## LA CUENTISTA SUBDIVISION – Unit III

May 19, 2008

**Re: La Cuentista Unit III Drainage Report and Grading Plan  
Engineer's Stamp dated 4-18-08 (D10/D002A)**

CITY OF ALBUQUERQUE PUBLIC WORKS DEPARTMENT ENGINEERING GROUP			
LA CUELISTA SUBDIVISION - UNIT III GRADING PLAN			
Design Review Committee	City Engineer Approval	Last Design Update	
City Project No. XXXXXX	Zone Map No. C-11, D-11	Drawing 2 of 3	Sheet

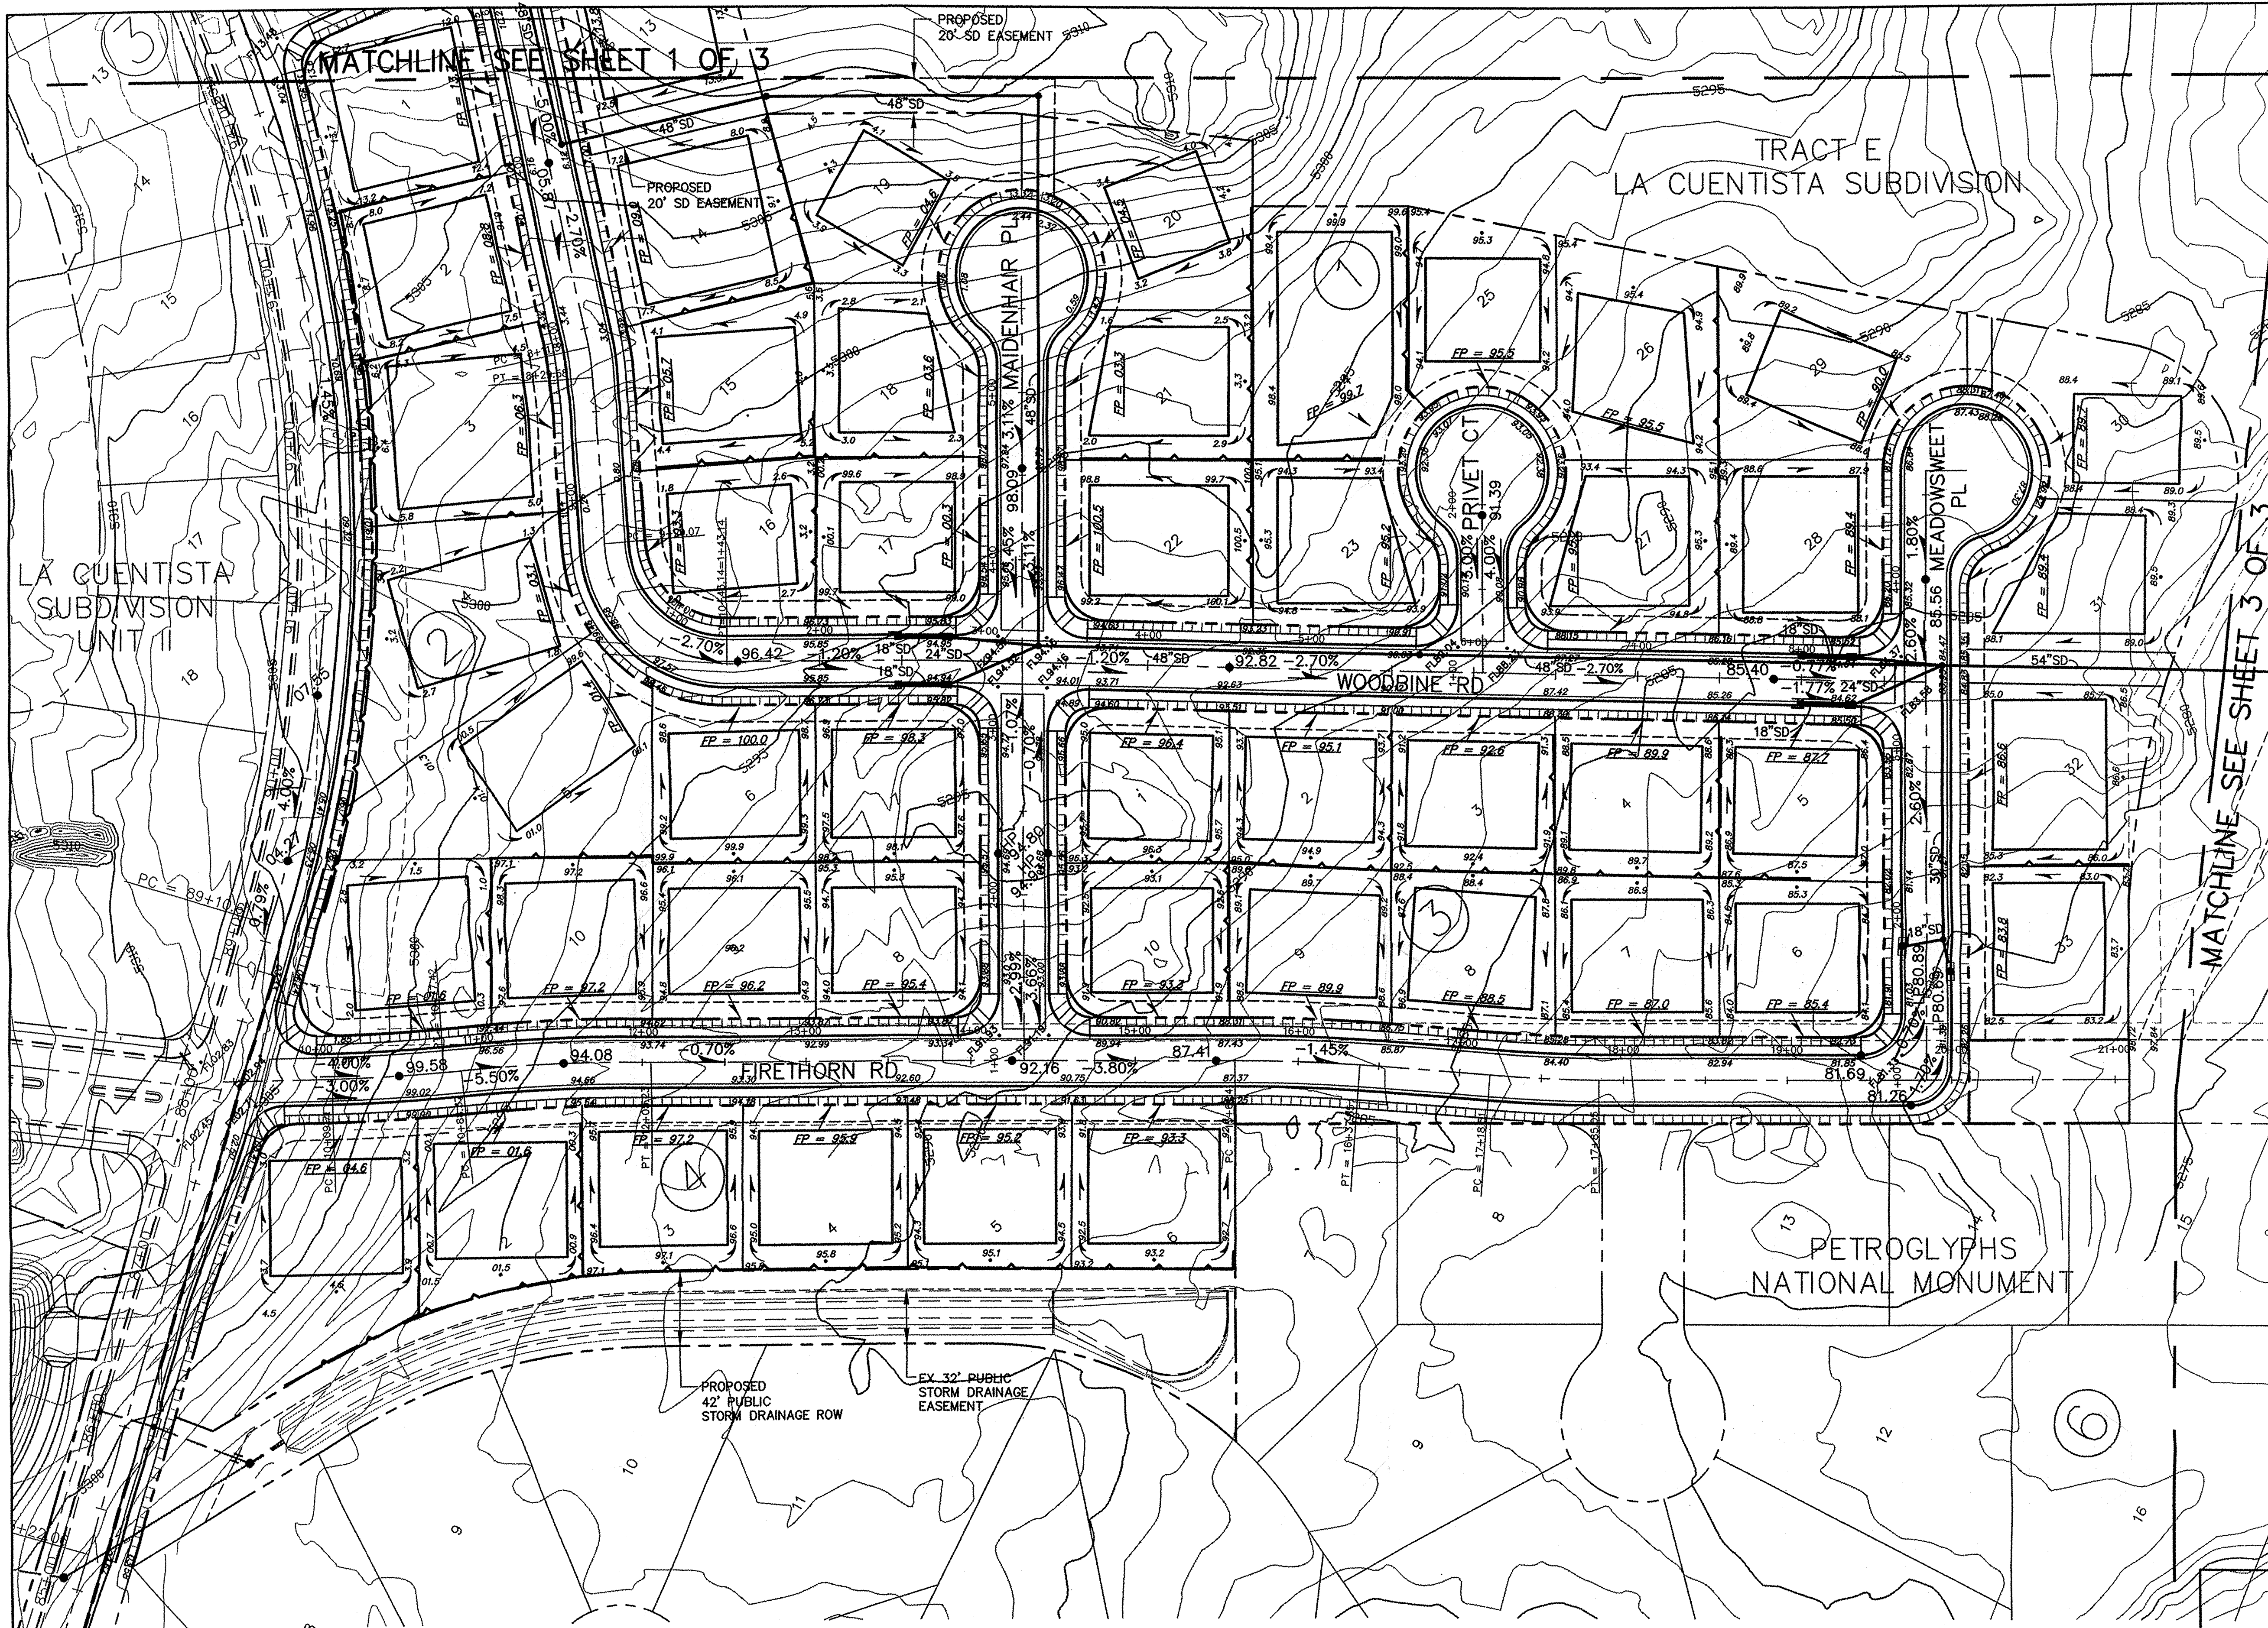
Inlets are required on Willowleaf PL to prevent runoff from leaving the street where Willowleaf PL meets Woodbine Rd.
